From: Stuart Corbey
Sent: 13 December 2018 15:15
To: Planning.Responses
Subject: FW: LU/201/18/PL - 137 Bayford Road

HMO PLAN

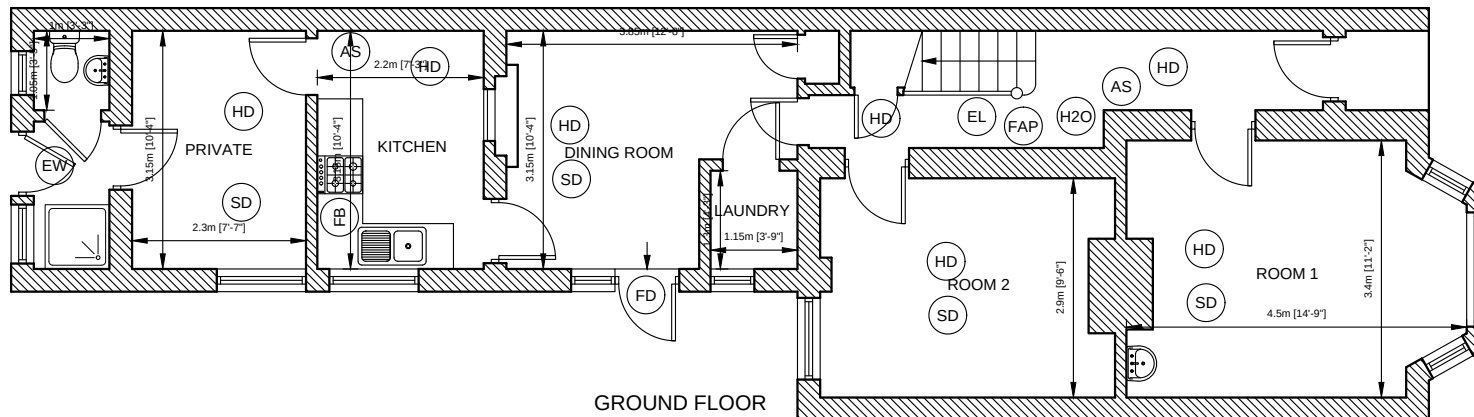
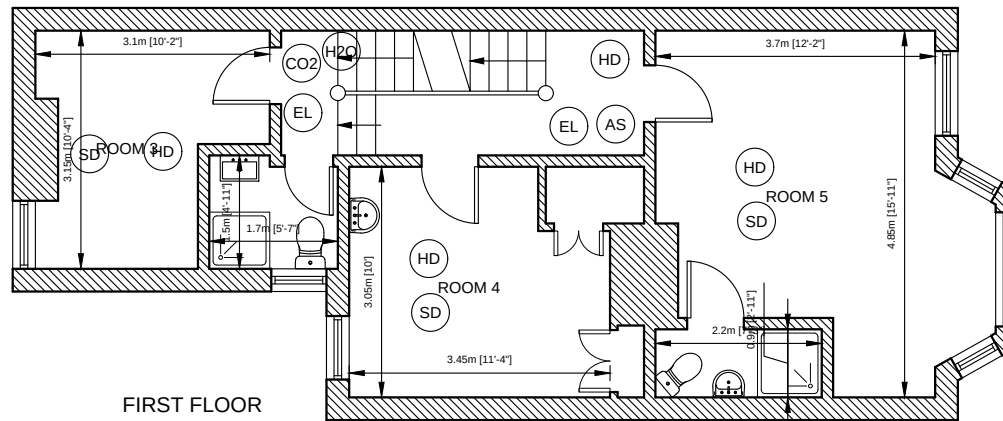
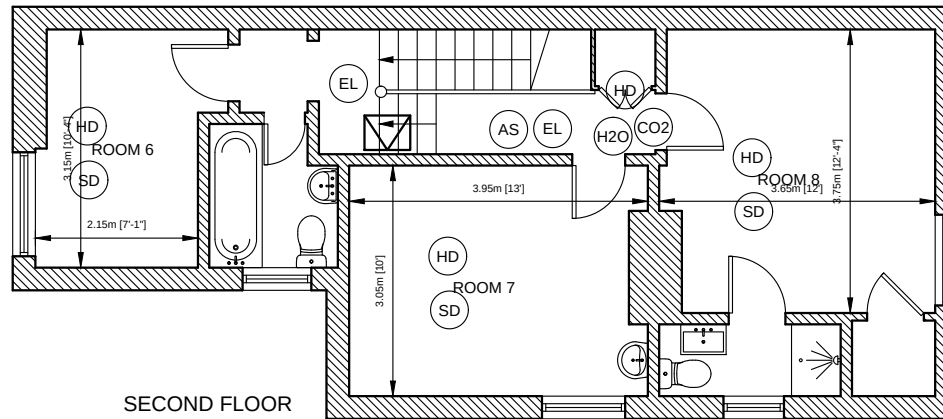
In consideration of the occupancy levels and the number of rooms as per the planning application submission. The floor plans indicate 8 rooms although you indicate 9 from the list below. In light of meeting the license requirements the property would need to retain the 8 rooms to a maximum of 14 persons.

Please can this be confirmed so we can agree to a specific occupancy rate and number of habitable rooms.

In regard to the two side windows one appears to be obscure glazed (with a makeshift – wooden slatted balustrade) and the rear one has been fitted clear glass – both freely opening. We are concerned with the safety of occupants whilst there is also a concern to the impact on overlooking to the residences at no.93. Ensuring these windows are of limited opening (for ventilation only) and both obscure glazed would be preferred.

There are 8 bedrooms for HMO use. There is also a room the caretaker sometimes uses to sleep in which is the room labelled 'private' on the ground floor.

The licence allows up to 15 which when including the caretaker is fine, so i am not sure what the problem is?

with regard to the two openings they are happy to replace both windows to limited opening with obscure glass and wish to proceed asap on this matter.
